Application Ref:	3/2025/0926			 Ribble Valley Borough Council www.ribblevalley.gov.uk
Date Inspected:	29/01/26	Site Notice:	29/01/26	
Officer:	LW			
DELEGATED ITEM FILE REPORT:				APPROVAL

Development Description:	Proposed change of use of land to provide dog day care area for an additional 16 dogs including a retrospective lean-to extension and exercise area, together a new exercise area, additional parking, extension to existing building, fencing and privacy screen netting and soft landscaping.
Site Address/Location:	Land at Mytton Fold Golf Course, Whalley Old Road, Langho, BB7 9JF.

EXISTING FLOOR PLANS @ ELEVATIONS

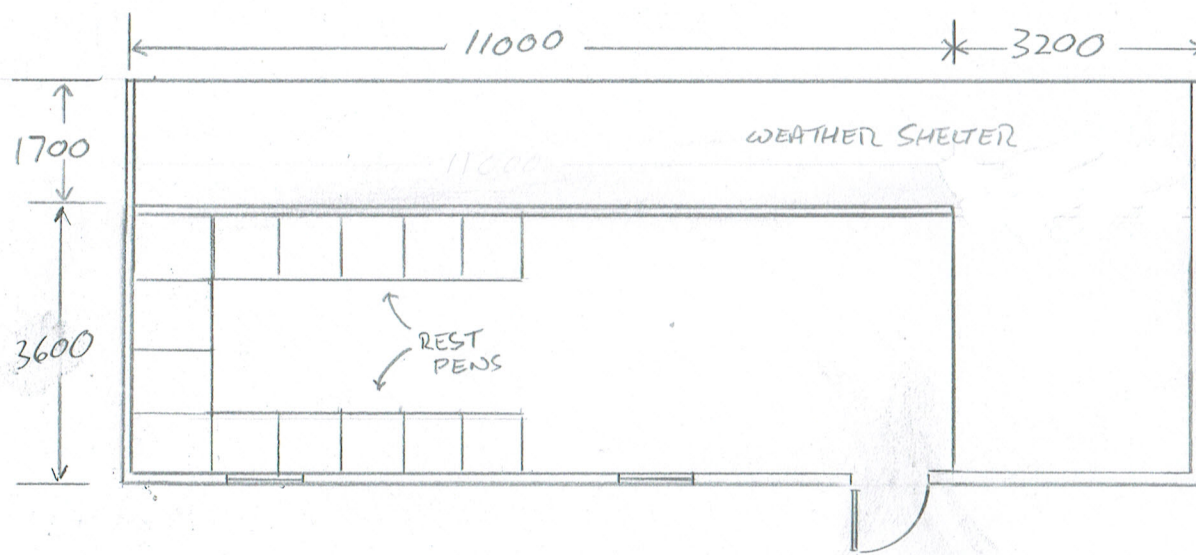
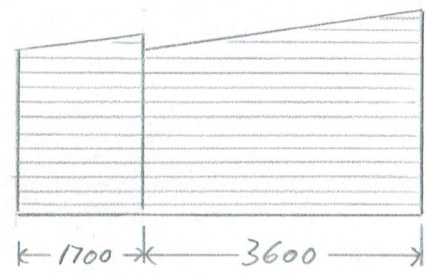
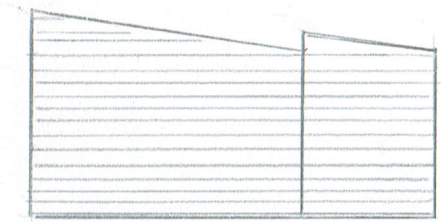
It is understood that the dog day care business in question has since proved to be successful, with the building having already been extended to provide an open sided shelter, while an additional external astro turfed play area has also been created to the south-western corner of the day care facility. Neither of these additions benefit from planning consent. Retrospective planning consent is thus sought for these, along with the creation of an additional exercise area on land adjacent to the existing access track and extended car parking area. It is also proposed to extend the existing building to the north-east by 7m x 3.6m to provide space for an additional 16 dogs. A new 2m post and wire stock fence is also proposed around the new exercise area, as well as Pro-Tec Brown Privacy Screen netting to remove inter-visibility between the golf course and dog day care facility.

In this respect, the proposed works would comprise a substantial expansion when compared to the extent of development granted permission under the original consent. With respect to the building itself, the submitted plans indicate an approximate increase in floorspace from original to proposed of 160%. The submitted 'Supporting Planning, Design and Heritage Statement' also provides a comparison of volumes taking account of the original structure and the proposal. These calculations indicate a 152% increase in volume from original to proposed. The proposed extensions would thus clearly result in a disproportionate addition to the original building in as much that the cumulative increase in floorspace and volume would be significant in relation to the original building. As such, the development cannot reasonably be argued to satisfy Green Belt exception c) which relates to the extension or alteration of an existing building.
